**KIRKLEES METROPOLITAN COUNCIL
INVESTMENT & REGENERATION SERVICE**

Reference No:	2025/62/92515/W
Site Address:	Millmoor House, 45A, Colders Lane, Meltham, Holmfirth, HD9 5JL
Description:	Erection of two storey rear and single storey rear/side extensions
Recommending Officer:	Molly Storer

OFFICER REPORT

client	MR & MRS SIDDALL		
project	PROPOSED EXTENSION 45a COLDERS LANE MELTHAM HOLMFIRTH HD9 5JL		
drawing	PROPOSED ELEVATIONS		
revision	notes	date	drawn
scale :	1:50 AT A1	09.25	JH
project no.	2437	drawing no.	03

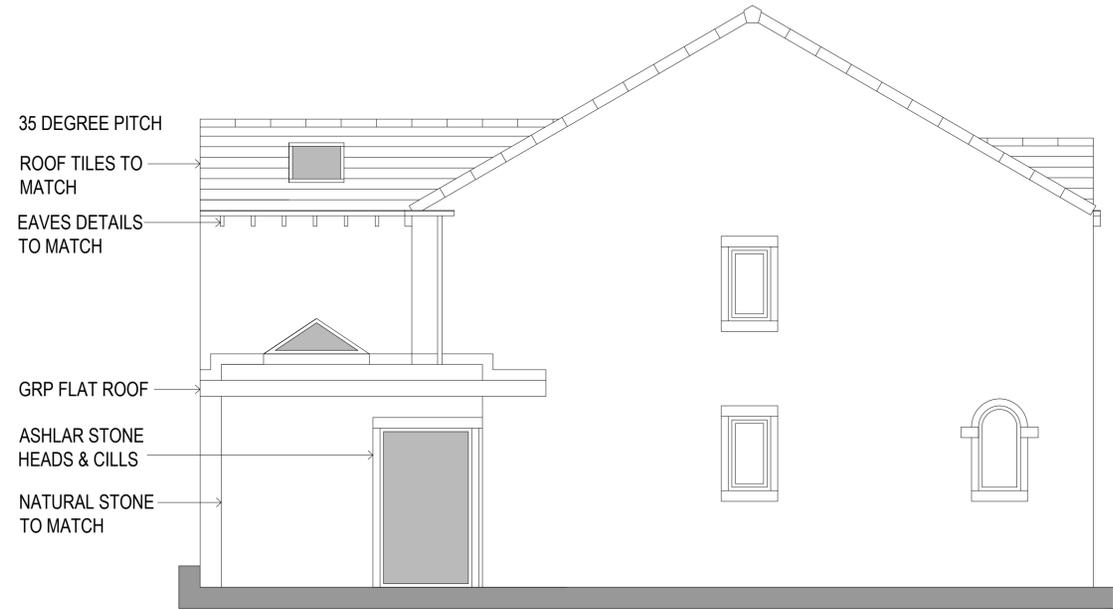
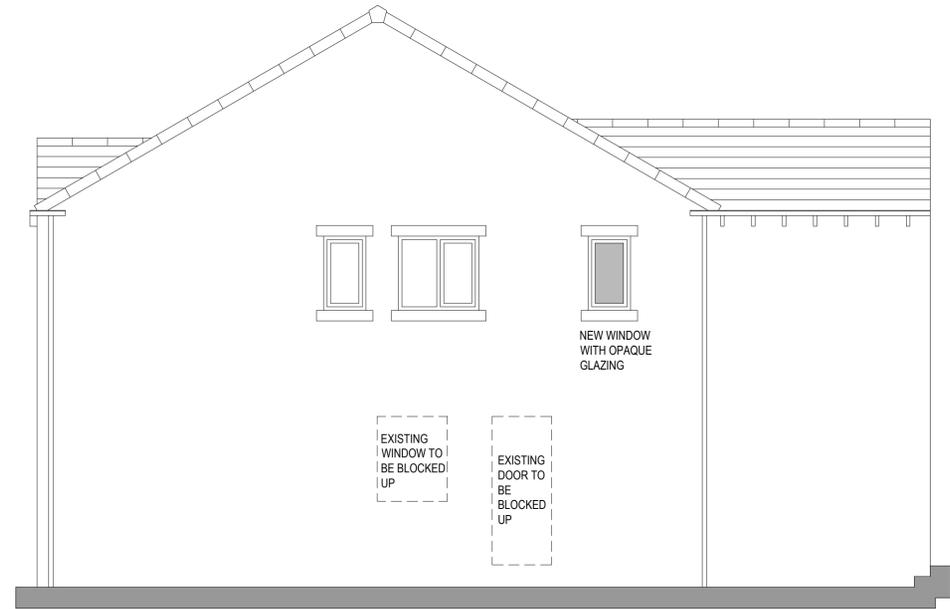
A new window would be inserted as part of the development in the side of the host property at the first floor level to the south elevation. On the basis this is obscure glazed (as annotated on the plan) this window is not considered to introduce significantly greater levels of overlooking. A condition to ensure this is the case is recommended.

4. The development shall not be occupied until the first floor window in the south elevation of the development hereby approved annotated 'new window with opaque glazing' within submitted drawing ref 03 has been fitted with obscure glazing or permanently affixed film which achieves an obscurity of Pilkington level of four or equivalent. Notwithstanding the provisions of the Town and Country Planning (General Permitted Development) Order 2015 as amended (or any Order revoking or re-enacting that Order). The obscure glazing or permanently affixed film shall thereafter be retained for the lifetime of the development.
